Application for a Non-Material Amendment Following a Grant of Planning Permission

SINGLE STOREY REAR EXTENSION

23/01802/FUL

PROPOSED ROOF PLAN
Scale 1:200

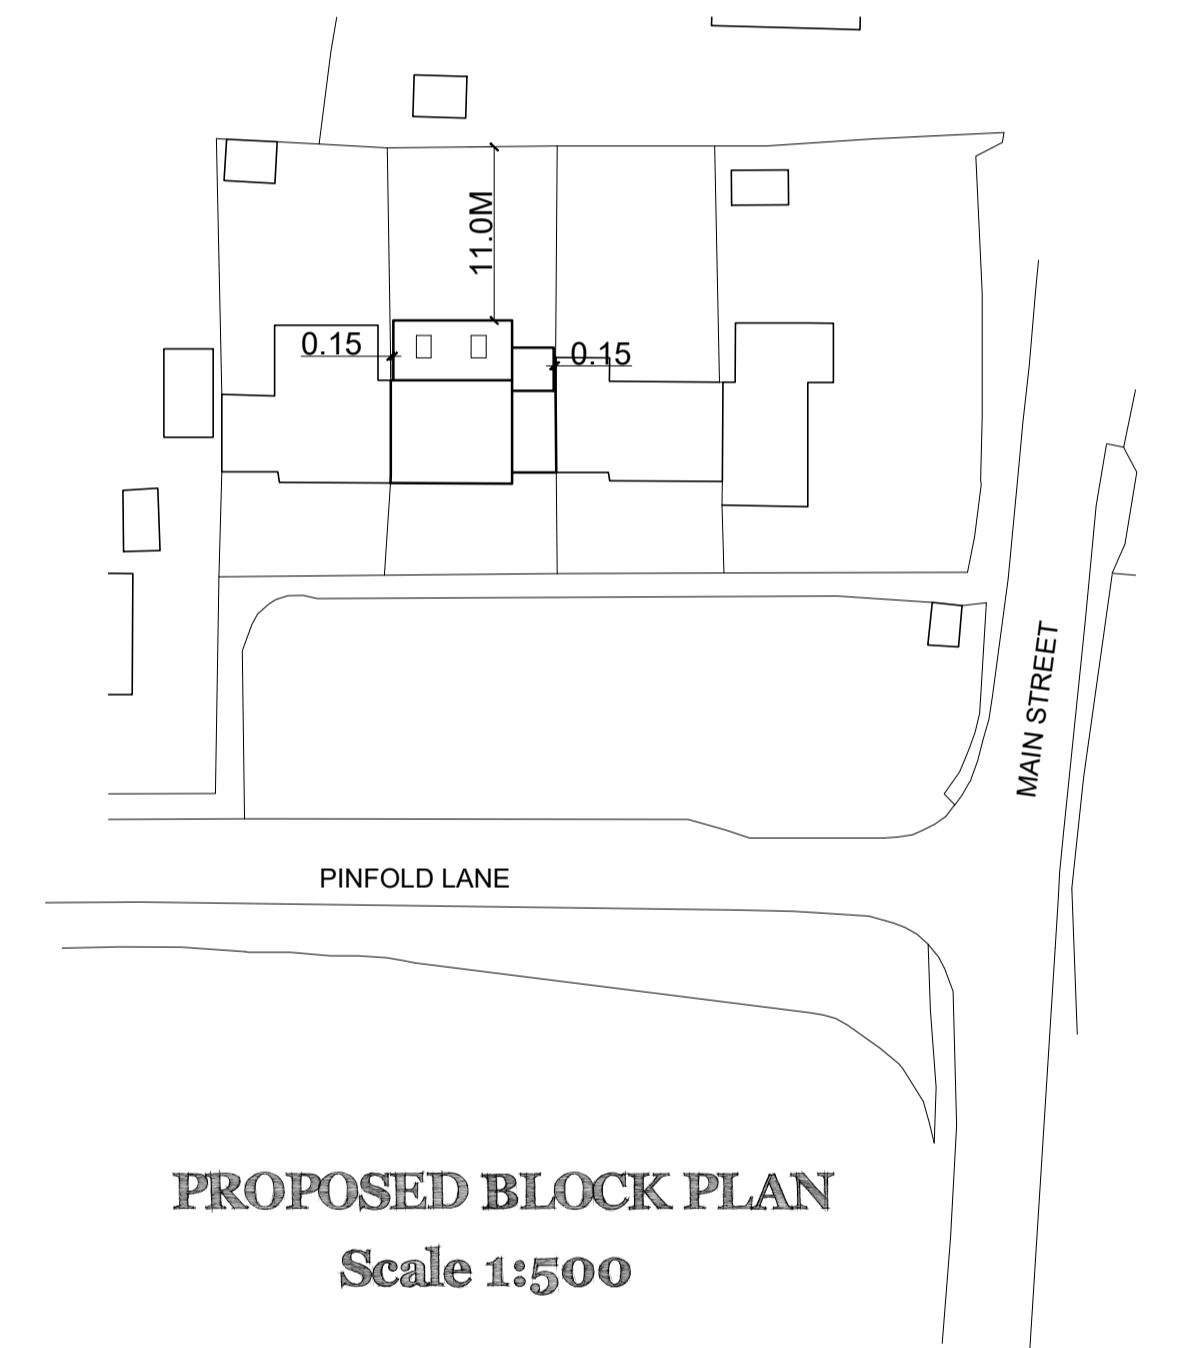
ADDITION OF 2 ROOFLIGHTS TO FLAT ROOF. ROOFLIGHTS TO BE FLAT.
